Application No: AW/3/21/HH
Site Address: 4 Shorecroft Aldwick PO21 4AS
Description of works: Single storey rear extension and loft conversion with enlarged rear dormer window and two modest front facing dormer windows. Alterations to fenestration, Canopy to side elevation, Planter and replacement handrail to roof terrace.

Thank you for your internet representation made on 8th February 2021 which has been recorded as an objection with the comments as follows:

Drawing No. Date:
C.1062H - 04 22-12-20

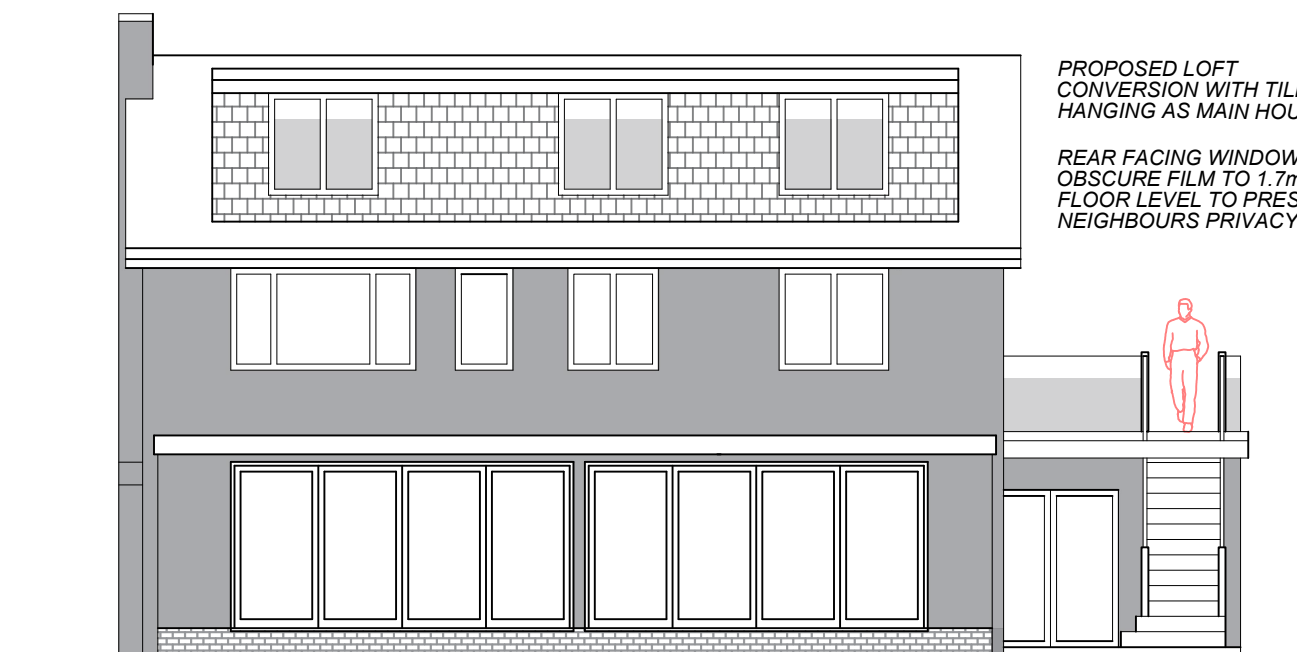
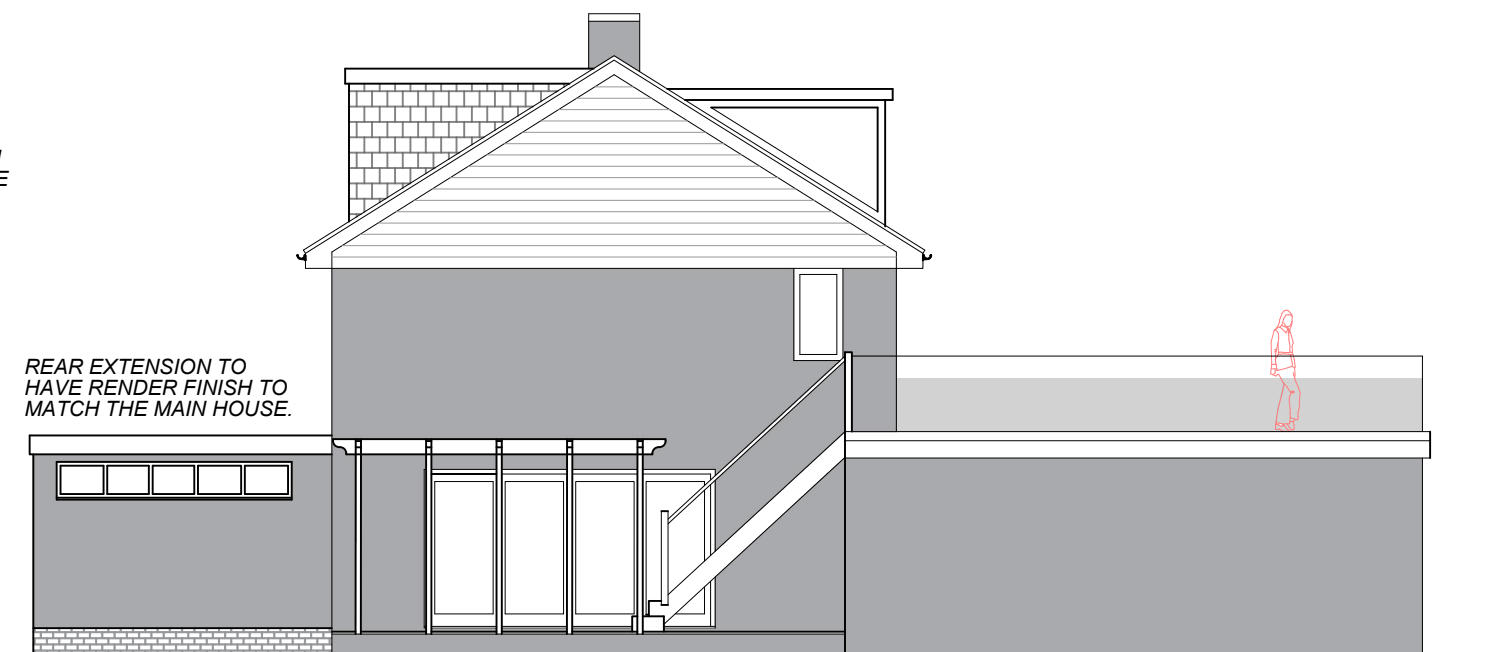
- 1) The roof dormer at the rear is over domineering to the house and is oversized.
- 2) The front dormers are similarly domineering and oversized.
- 3) The house is part of an integrated estate comprising two storey houses, chalet bungalows and bungalows. There are no roof extensions creating three storey houses.

- 4) The proposed dormers are flat roofed.
- 5) The aesthetics of the front and rear dormers with their flat roofs are overpowering and spoil the roofscape and visual and neighbourhood amenity of the estate.

- 6) The roof dormers are not modest as described in the Design and Access statement.
- 7) The dormers bear no resemblance to the single dormers on each of nos. 7 and 9 Hornbeam Close which are far smaller than the proposed large rear dormer and the two front dormers proposed.

- 8) We do not agree with the statement that "the scale and format of the development is proportionate to the site and local setting". In respect of the roof dormers we think the opposite is true and totally disproportionate.
